From: Antonia CATLOW [REDACTED]
Sent: 16 May 2019 16:05
To: Anita Gardner
Cc: Craig Noel
Subject: RE: A/175/18/PL - Caffyns Temporary Car Park Extension - Drainage

From: Laura Gibbons
Sent: 09 May 2019 10:56
To: 'Steve English'; Anita Gardner

As stated previously I require shallow infiltration testing to be completed in the winter. The testing which is included in the additional documents was completed at far deeper depths. And therefore not suitable to assess the adequacy of design.

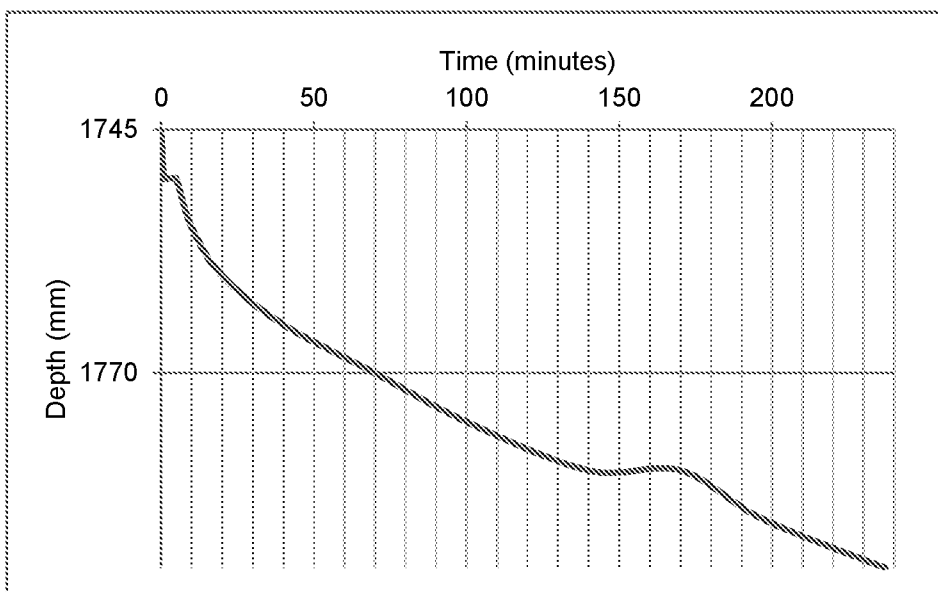
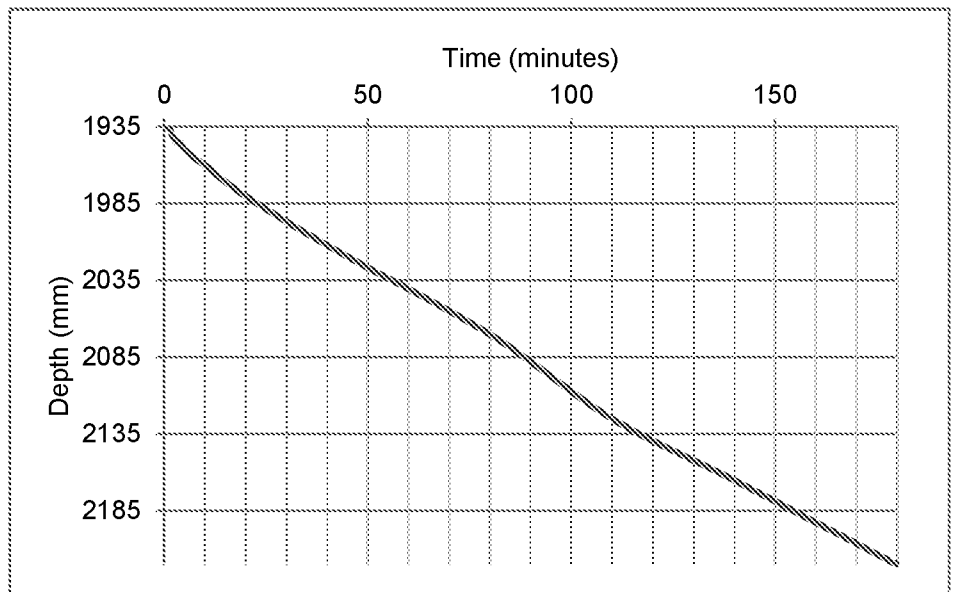
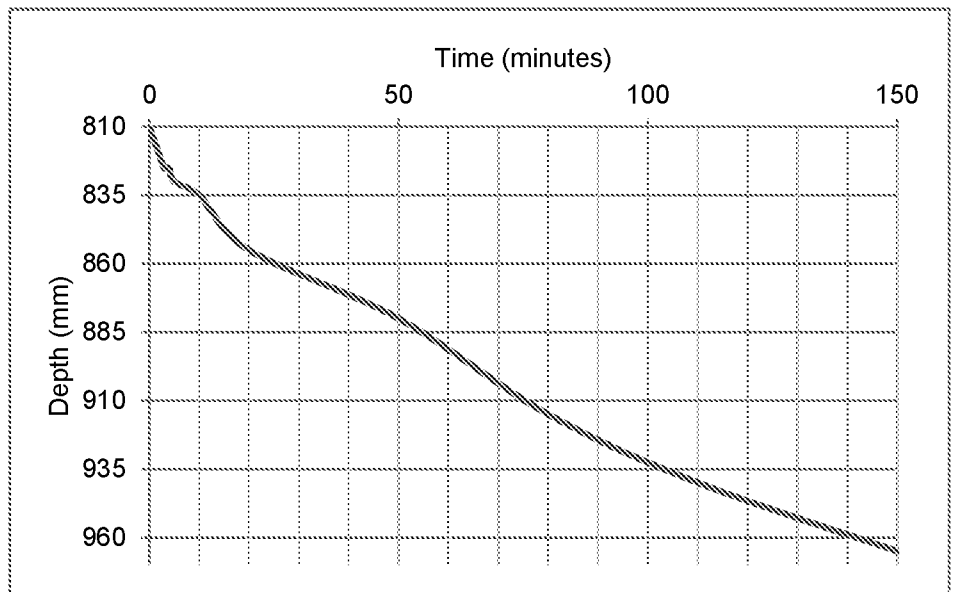
As stated previously I require shallow infiltration testing to be completed in the winter. The testing which is included in the additional documents was completed at far deeper depths. And therefore not suitable to assess the adequacy of design.

As noted in the revised Drainage Strategy (additional PDF copy attached for information purposes) and subsequently discussed direct with Anita, the proposed works would in fact be a betterment to the current situation on this land with regard to the accommodation of surface water during high intensity rainfall events. There will in fact be an increase in

permeable surfacing and the level alteration would result in a greater capacity to retain surface water under particularly high intensity storm events.

The land clearly performs (i.e. drains) adequately at present. It seems an unreasonable request to insist on shallow percolation testing when in fact there is to be an increase in permeable area, an improvement in the permeability of the surface generally and the provision of storm water attenuation capacity (both above ground and within the stone voids). In our opinion, insisting on shallow infiltration testing during a Winter period is unreasonable and obstructive request for an application of this nature – i.e. a temporary car park extension that is required to alleviate business disruption effects that will be imposed due to the upgrading of the A259.
